ENG-SP20008-R2-GEC-redlines Markup Summary

HOMESTEAD NORTH AT STERLING RANCH
EARLY GRADING & EROSION CONTROL PLAN

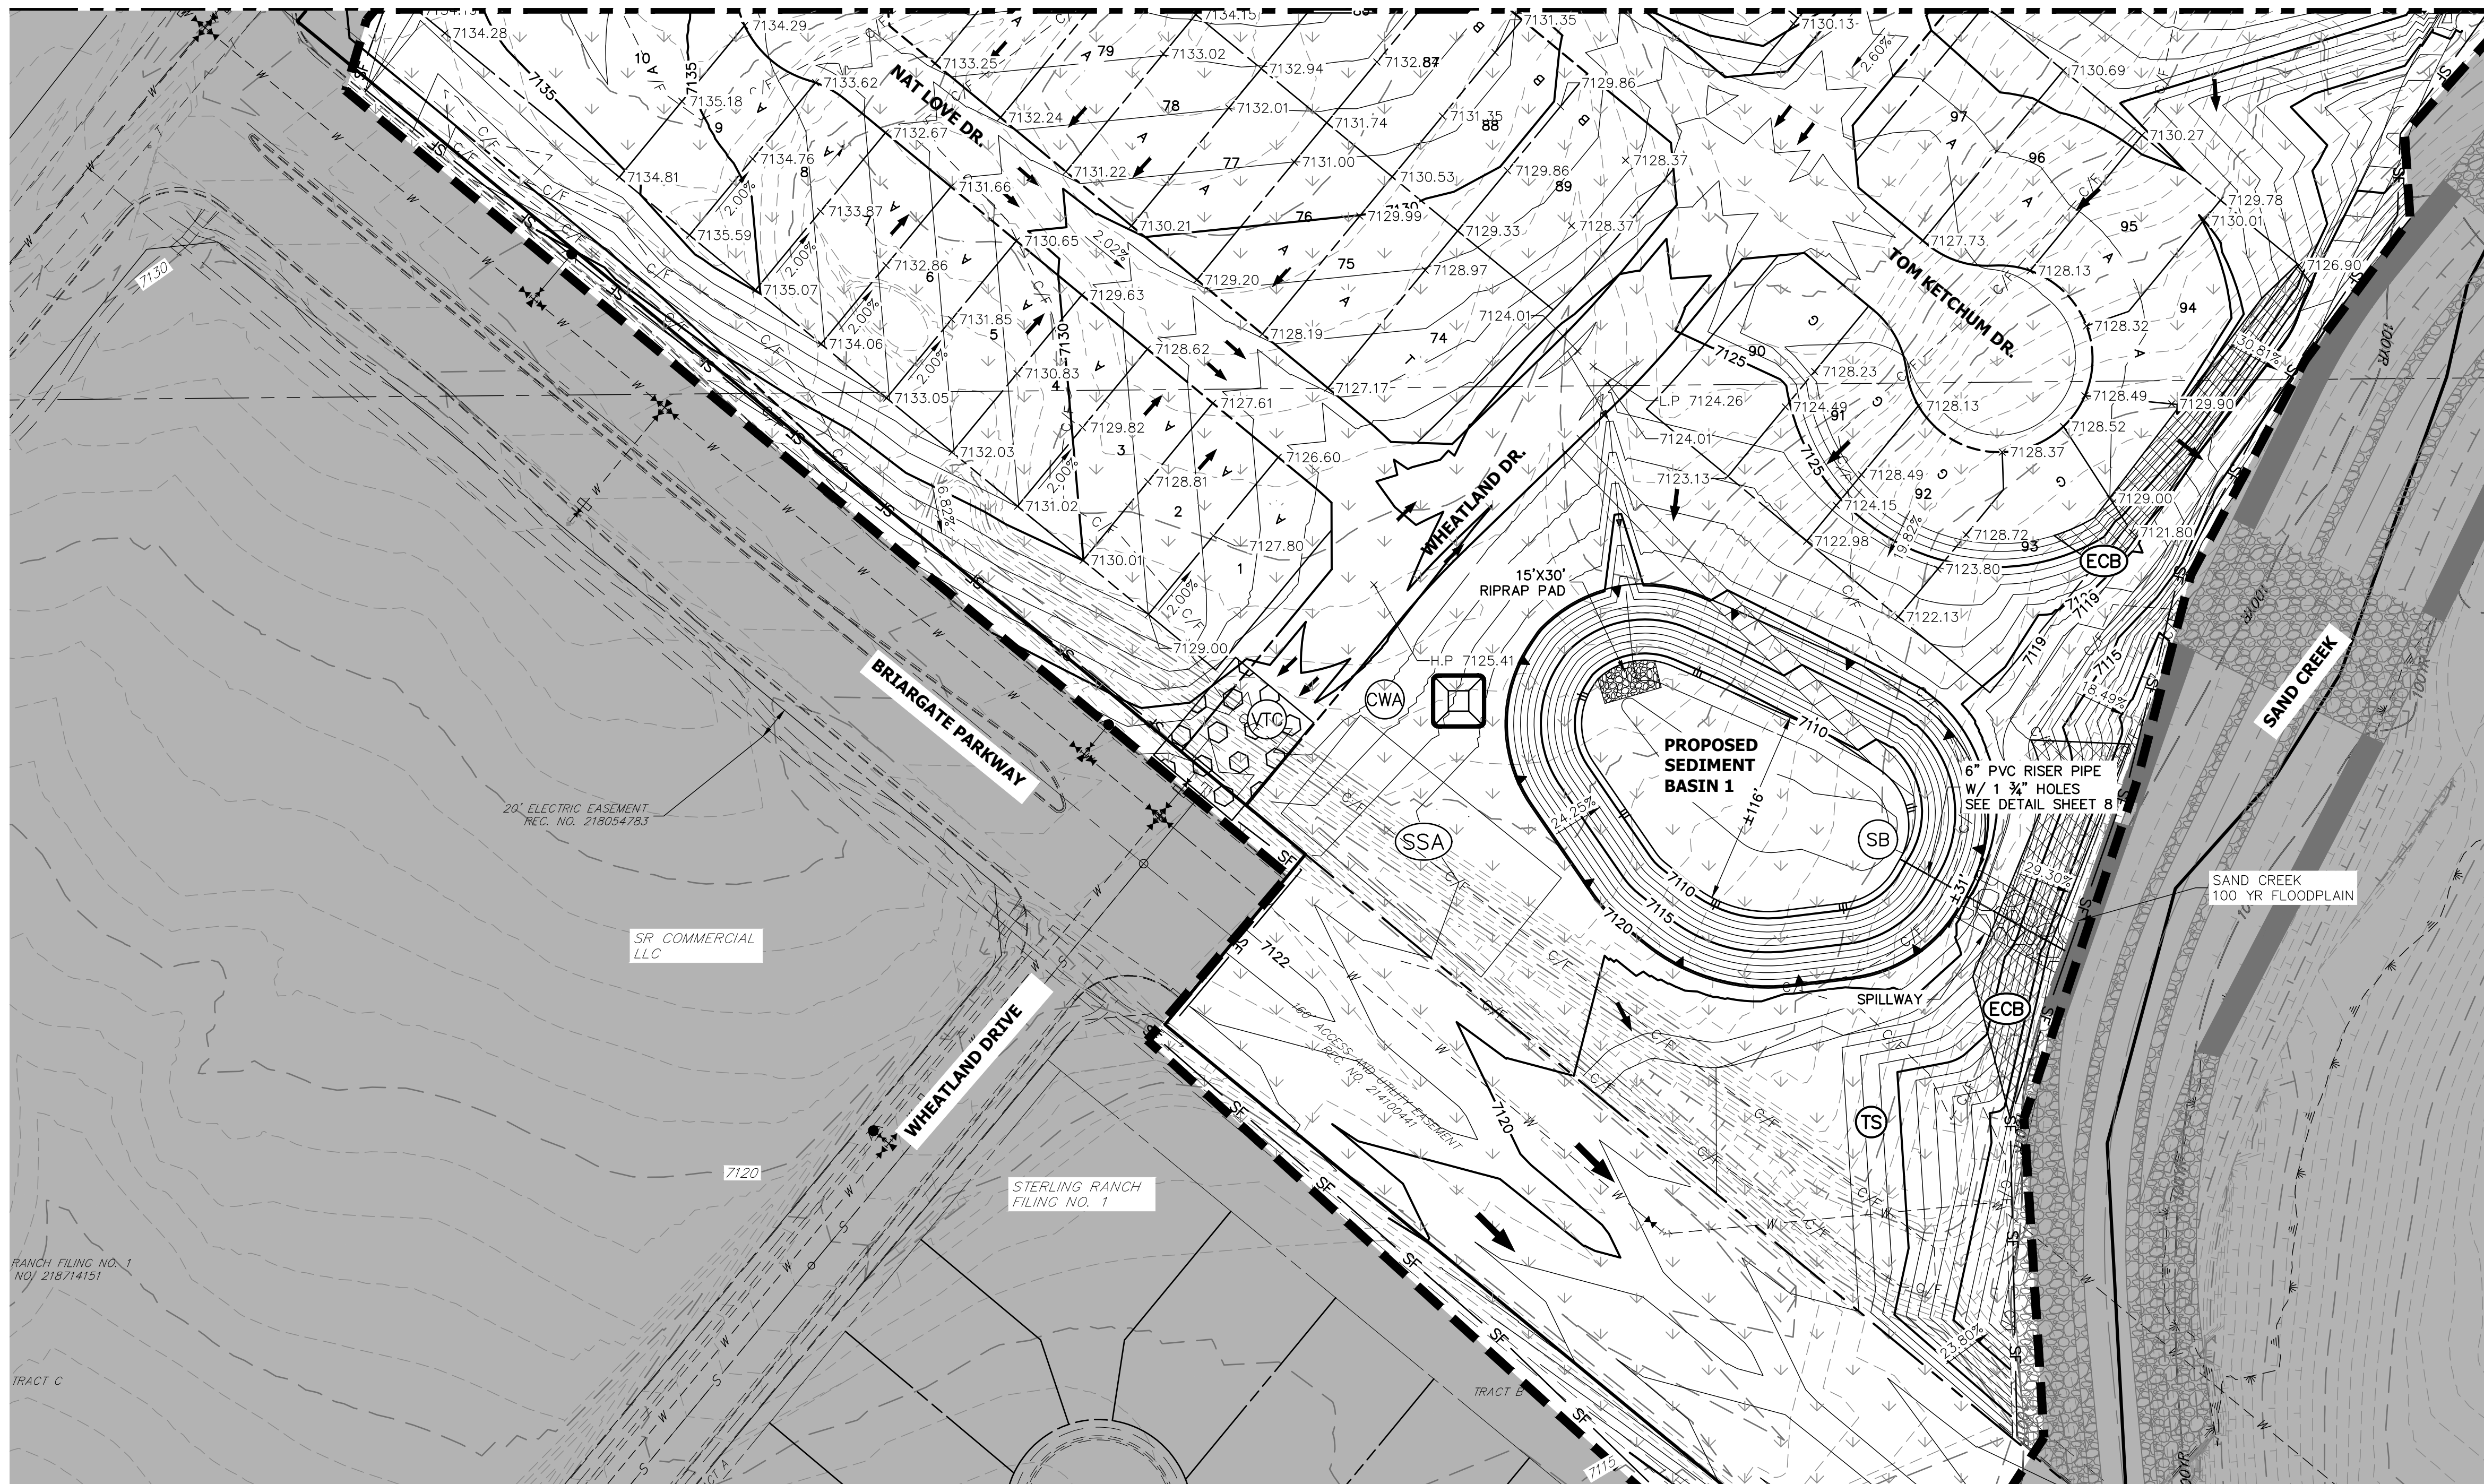
Show detail for CWA on last sheet.

Show check dams (rock socks, straw bales, etc) in rough cut street drainage (typical all sheets). And add detail of selected BMP to last sheet. Also see MHFD Detail EC-9 and add that to last sheet.
